**WELWYN HATFIELD BOROUGH COUNCIL
EXECUTIVE DIRECTOR - PLANNING, PUBLIC PROTECTION AND GOVERNANCE**

Application No: 6/2020/1872/LAWP
Location: 89 Lemsford Road Hatfield AL10 0DZ
Proposal: Certificate of lawfulness for hip to gable and dormer roof extensions.
Officer: Mr Tom Gabriel

6/2020/1872/LAWP

PROPOSED ATTIC 1:50

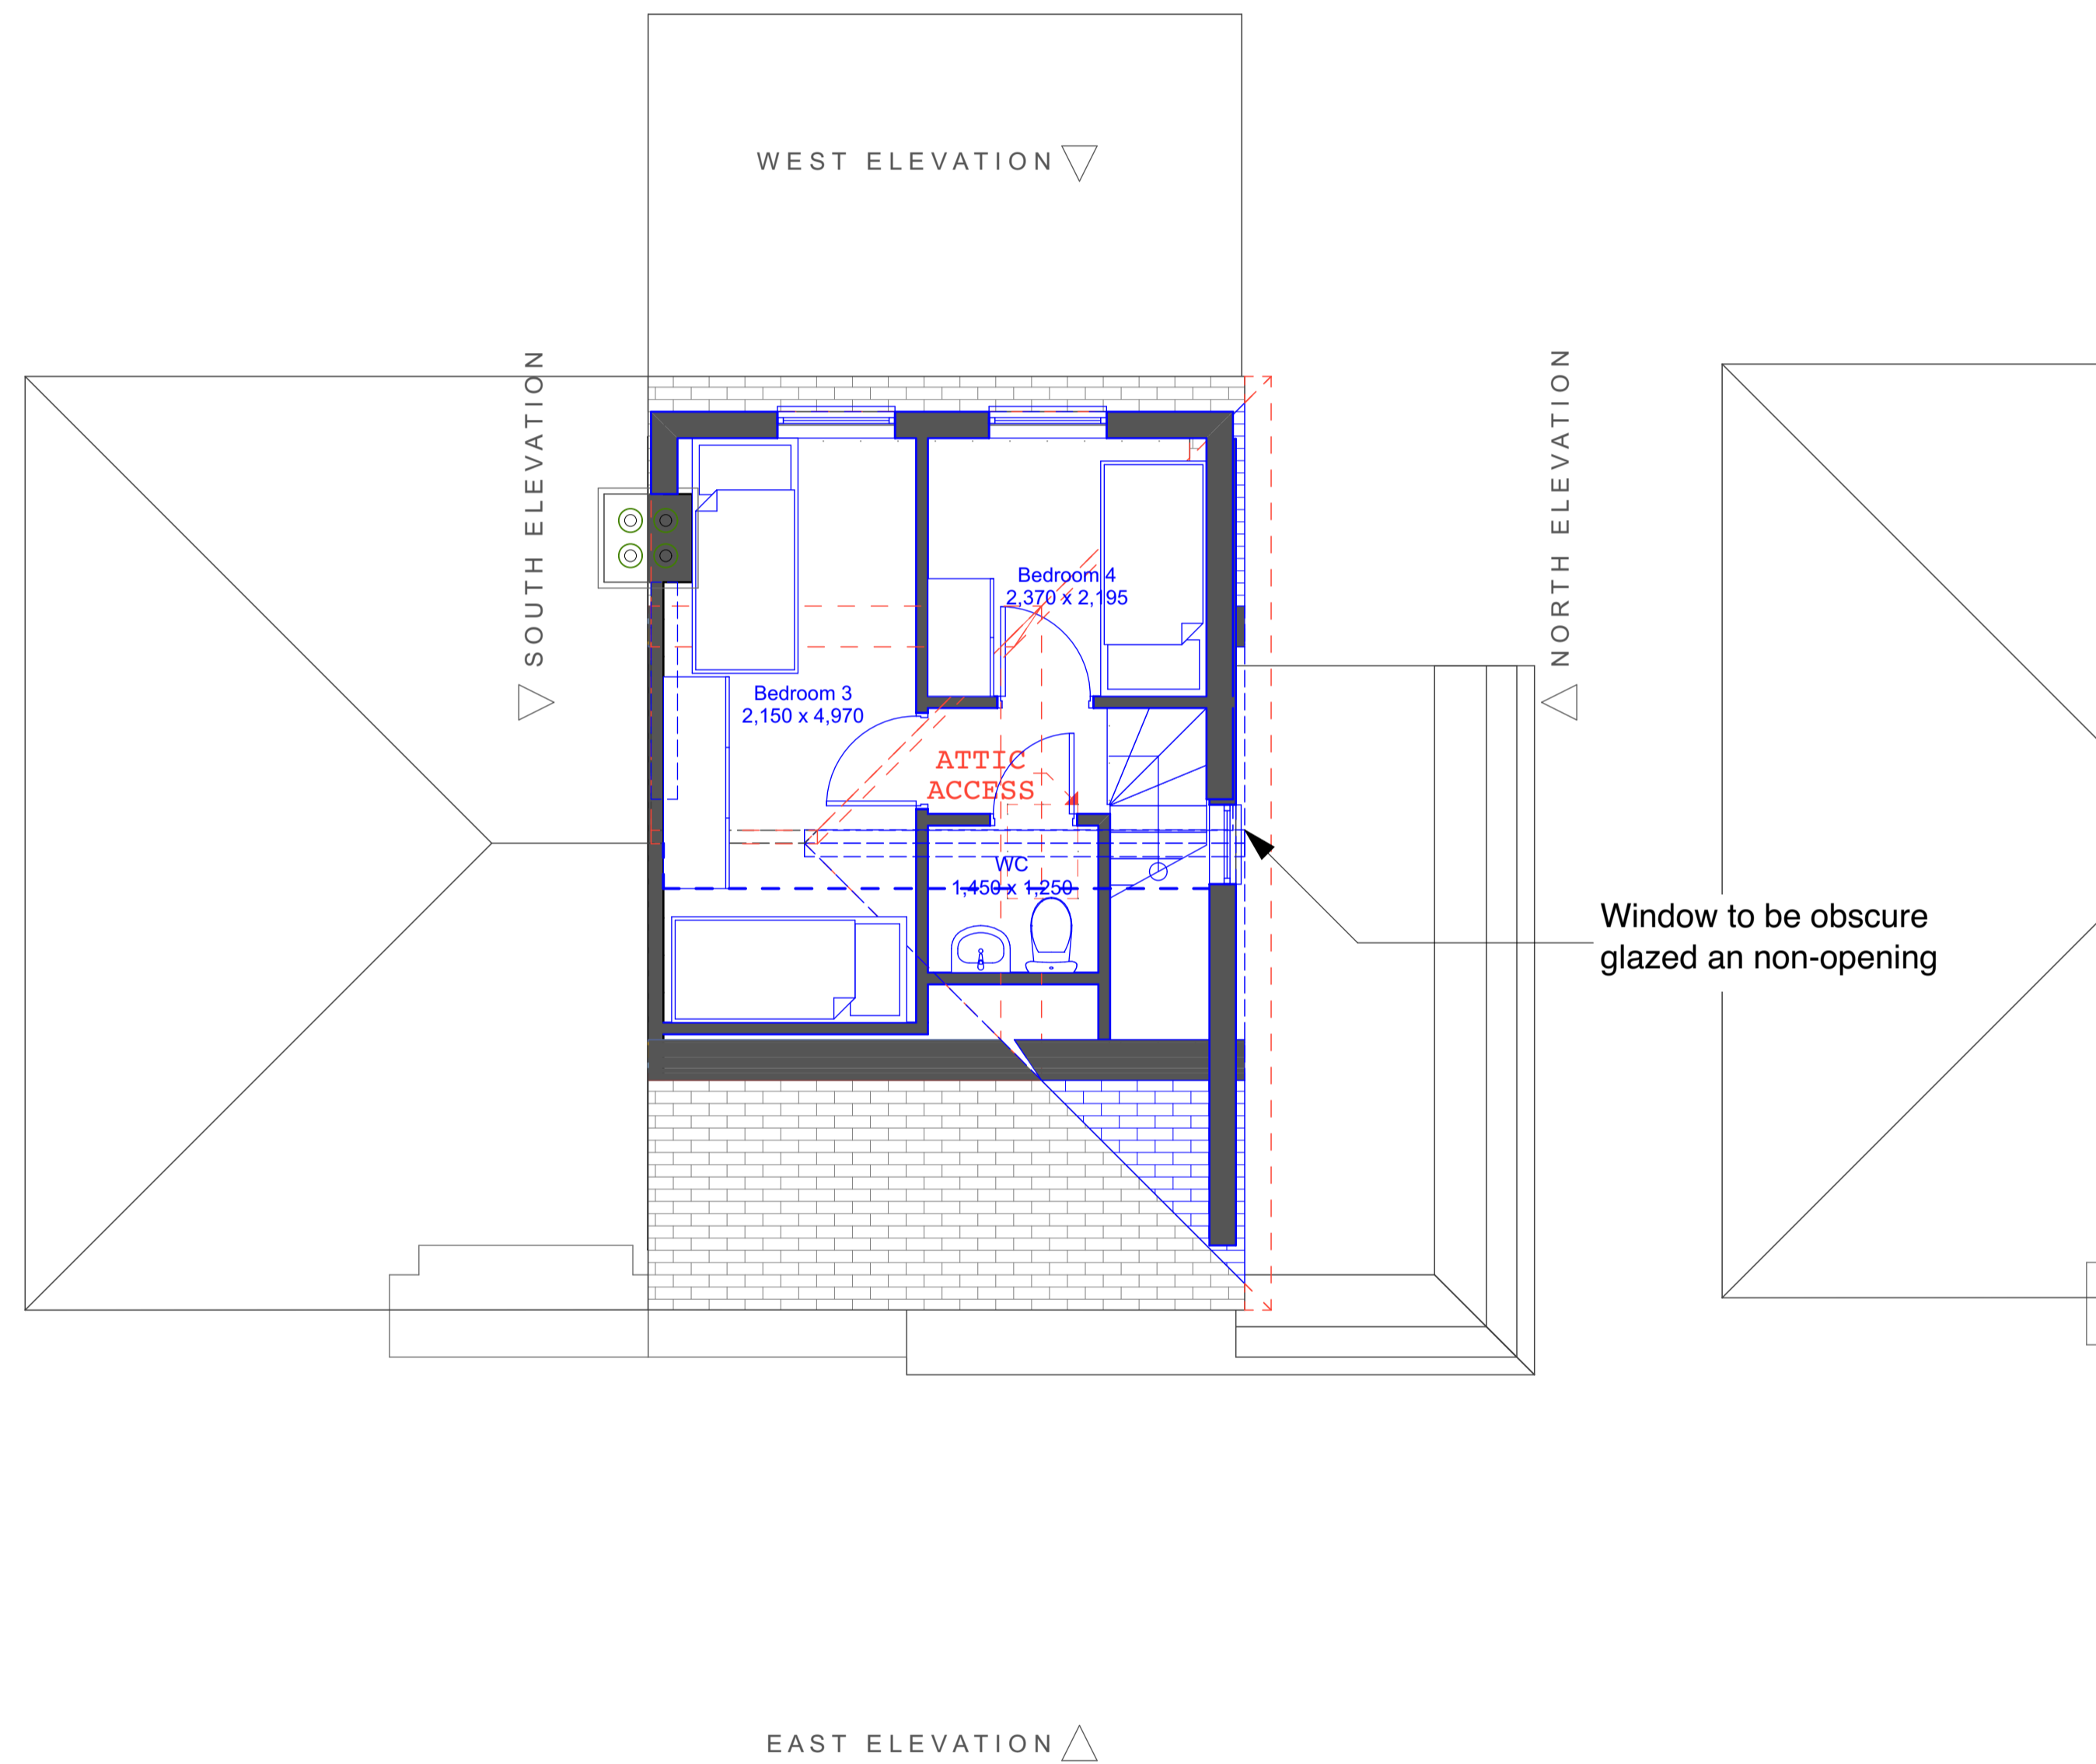
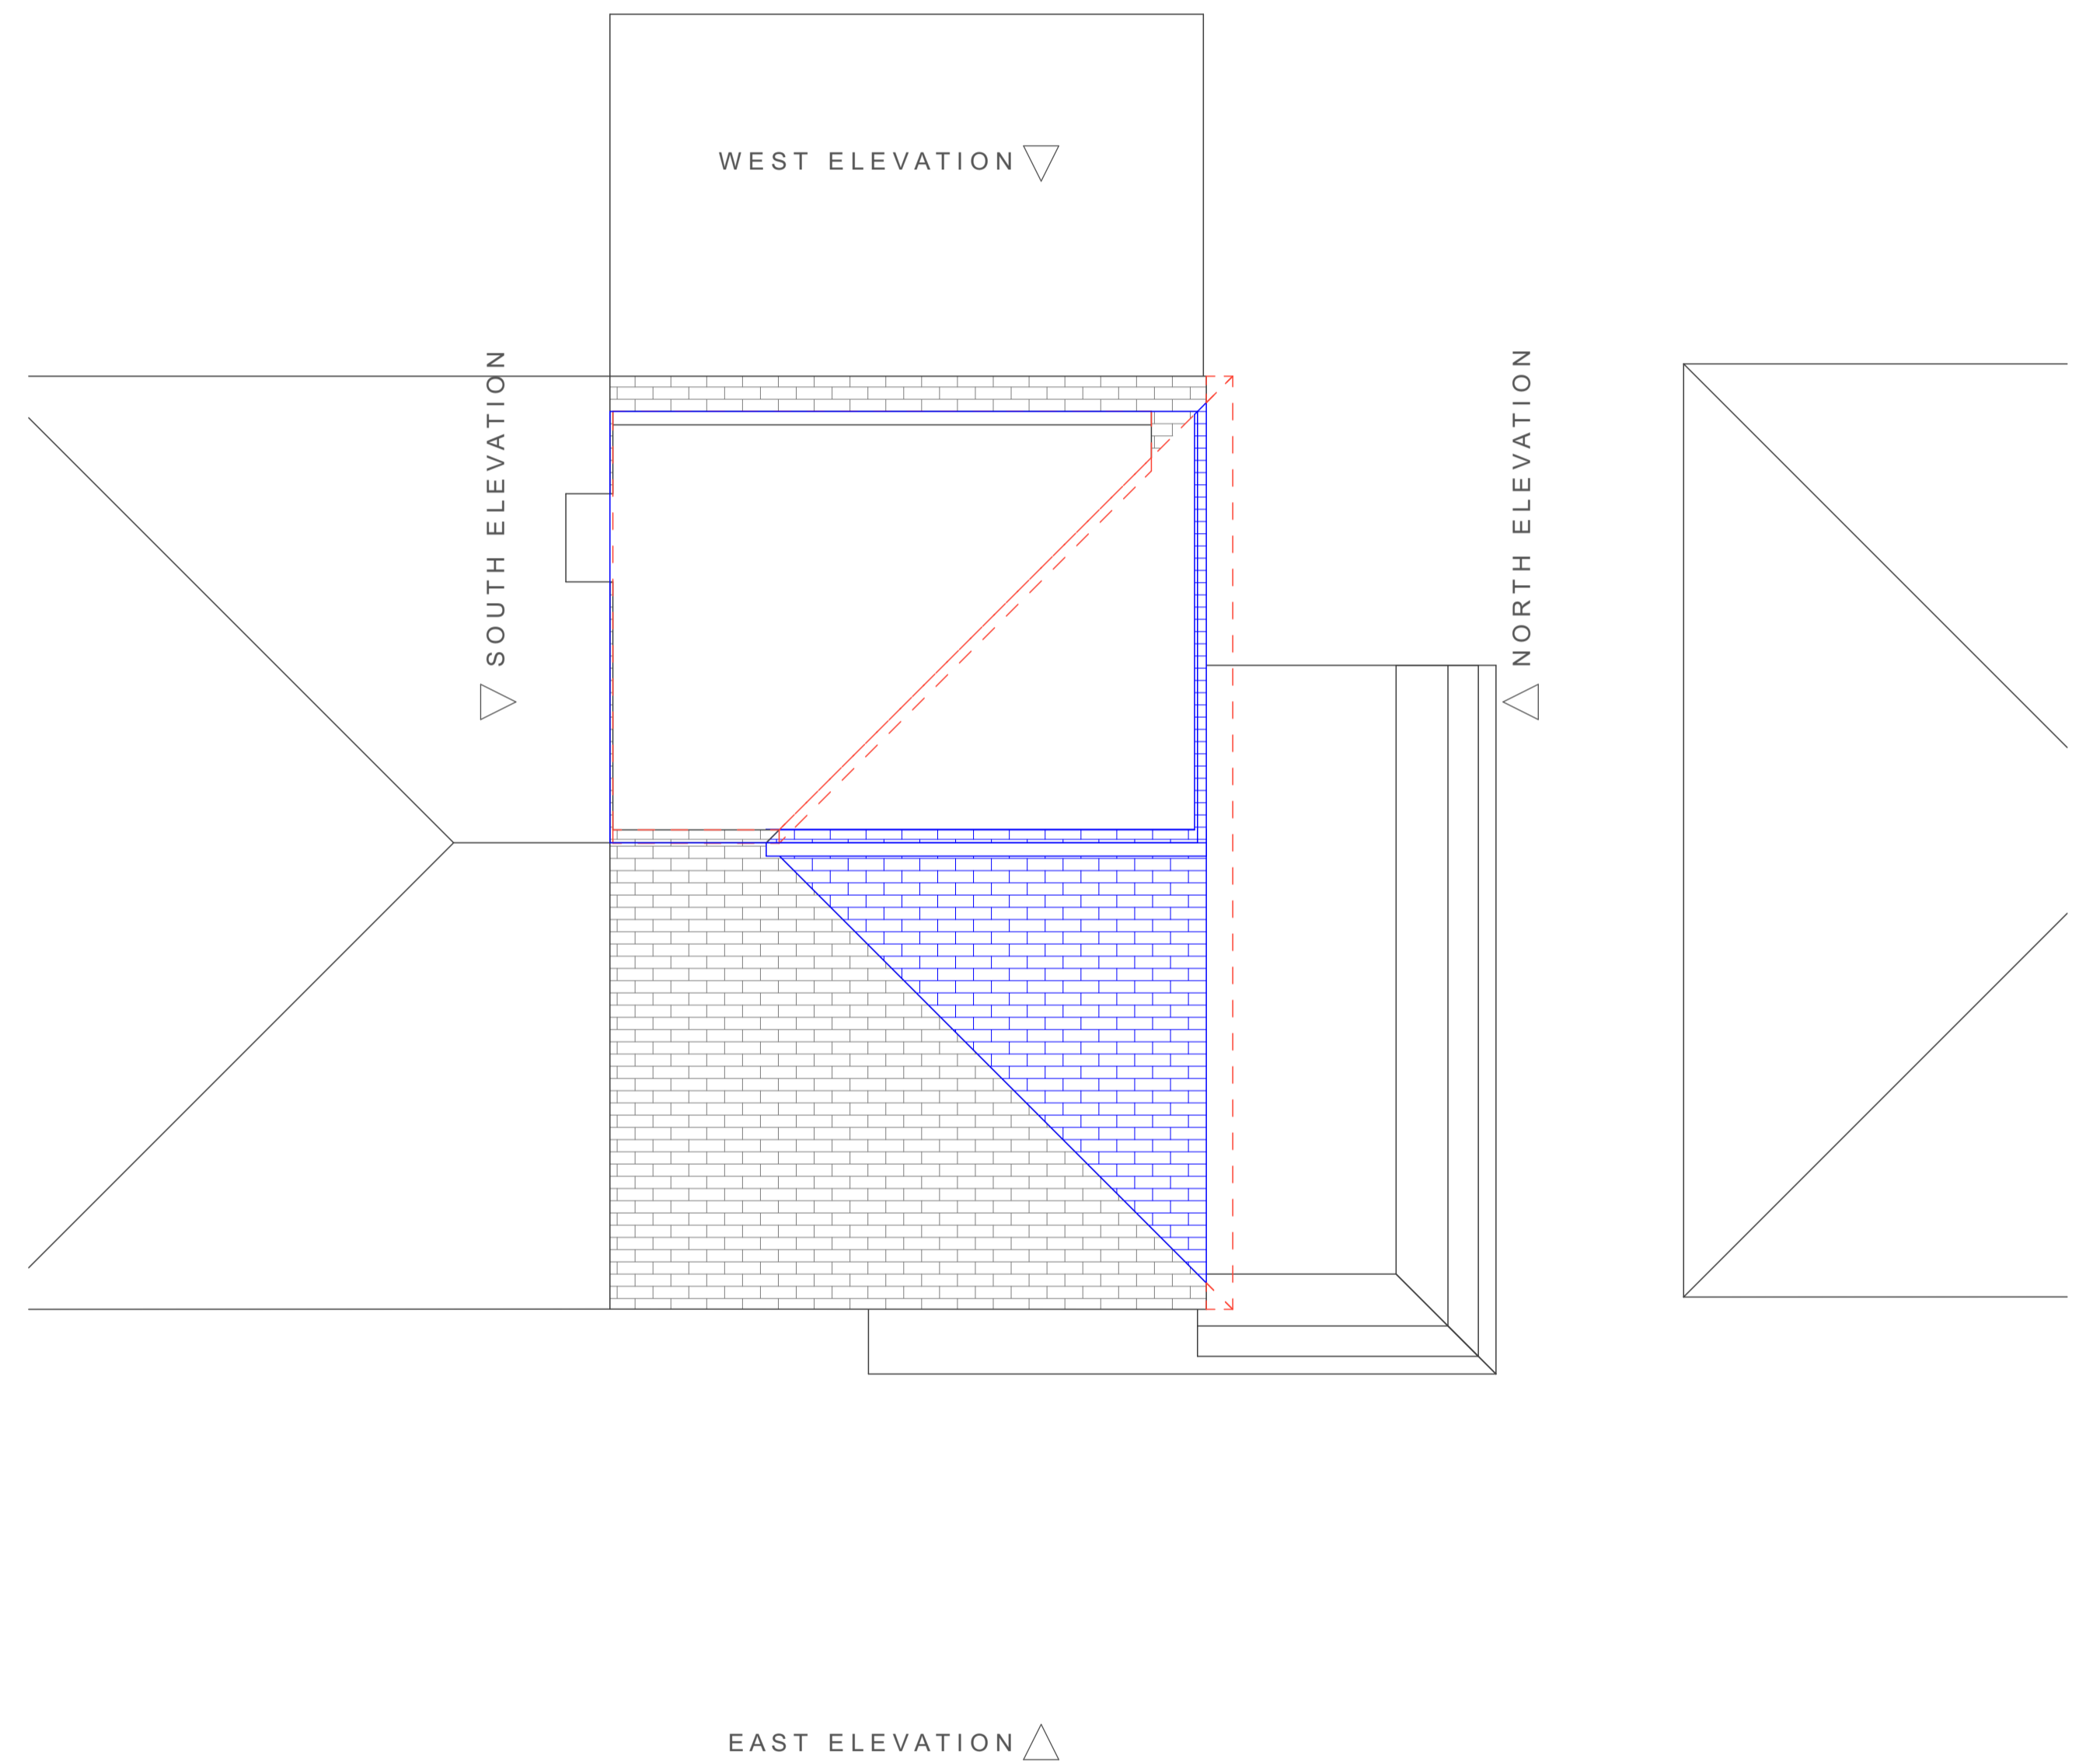
| (d) would the cubic content of the resulting roof space exceed the cubic content of the original roof space by more than:- (i) 40 cubic metres in the case of a terrace house, or (ii) 50 cubic metres in any other case | N see below | N |
| <p><u>Calculation</u></p> <p>Hip to gable : $(1/6 \times (7.5 (d) \times 3.7 (h) \times 2.7 (w))) = 12.49 \text{ m}^3$</p> <p>Dormer: $(1/2 \times (4.9 (w) \times 3.55 (h) \times 3.65 (d))) = 31.75 \text{ m}^3$</p> <p>Total = 44.24 m³</p> | | |
